RE: ENGINEER'S CERTIFICATION FOR AIRBORNE (N-15/D1A5) ,  
RECEIVED NOVEMBER 29, 1993 FOR CERTIFICATE OF OCCUPANCY APPROVAL  
STAMPED & DATED 11-22-93

RE: AIRPORT TECHNICAL CENTER EAST (N15-D1) BORROW SITE  
FOR SUNPORT PROJECT.

The following are City Hydrology's comments on your grading permit request. Given that this grading permit request is for a borrow pit for the Sunport project, which is not typical of development grading permit requests, I solicited comments from Loren Mainz for EPA requirements.

CITY OF ALBUQUERQUE PUBLIC WORKS DEPARTMENT ENGINEERING					
AIRPORT TECHNICAL CENTER EAST					
GRADING AND DRAINAGE PLAN					
APPROVALS	ENGINEER	DATE	APPROVALS	ENGINEER	DATE
ERIC CHADHAN			WATER		
TRANSPORTATION			WASTE WATER		
HYDROLOGY					
DRAWING NO.	MAP NO. N-15		SHEET 1		OF 1

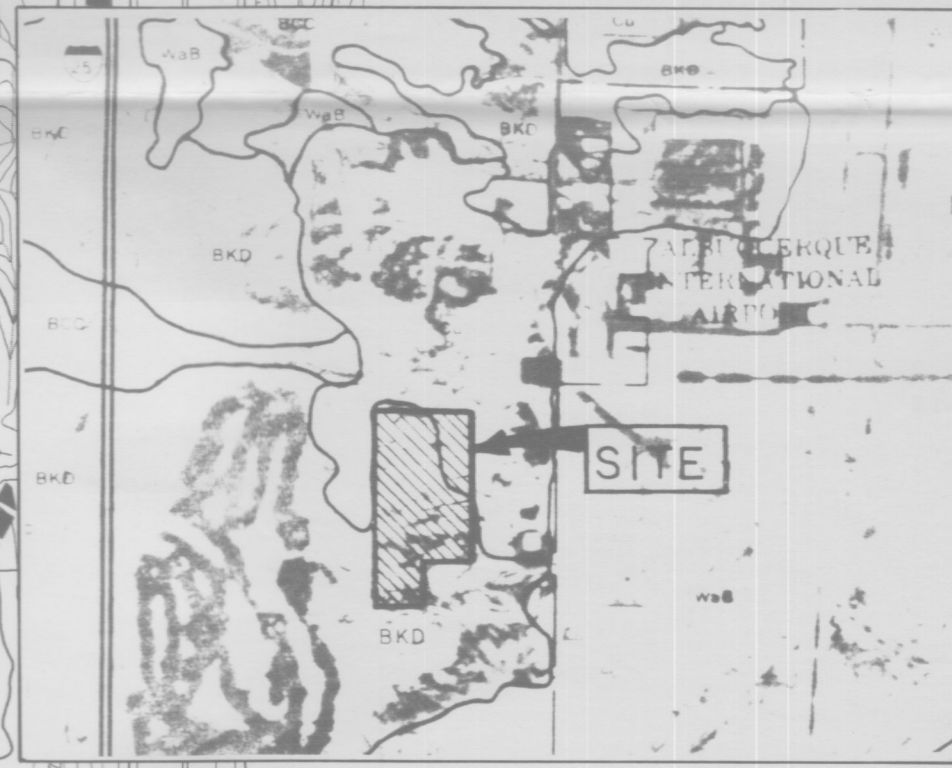
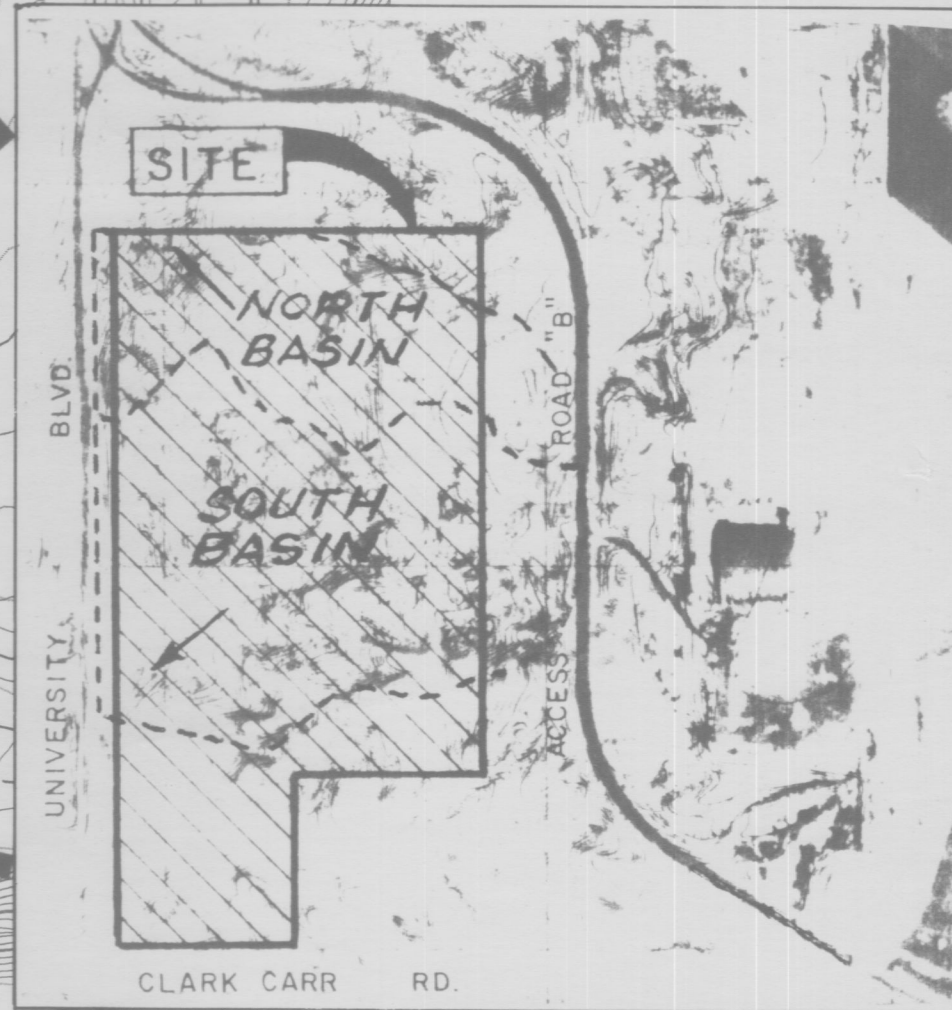
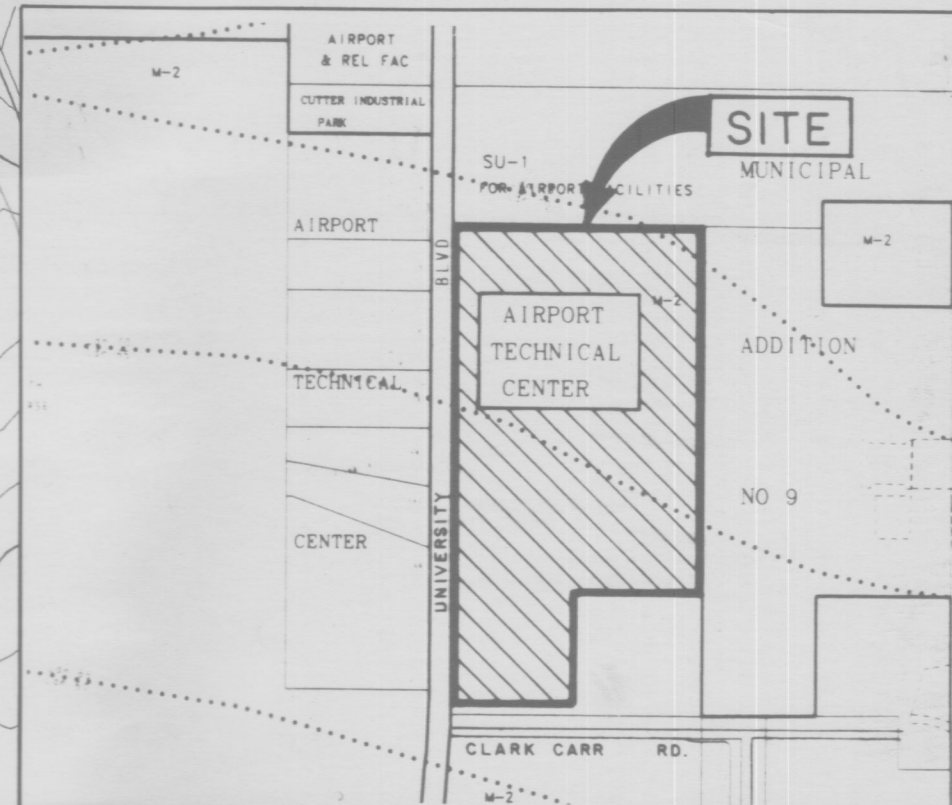
- The contractor must file a "Notice of Intent" (NOI) for construction activity with E.P.A. and must have an appropriate pollution prevention plan. See typical details in the Sunport Construction Plans for level of detail expected. The pollution prevention plan must address on-site disiltation ponds and must be maintained during construction and after construction until the vegetation has established. (NOI application attached).

- Provide existing and proposed ortho-topo map with horizontal and vertical control.
- Provide construction schedule for the borrow pit operation and the anticipated completion of final grading.

- Include with your resubmittal the calculations for the identified flow rates.
- Follow Section 1012 of the City Standard Specification and/or specific requirements addressed in the Topsoil Disturbance Permit.
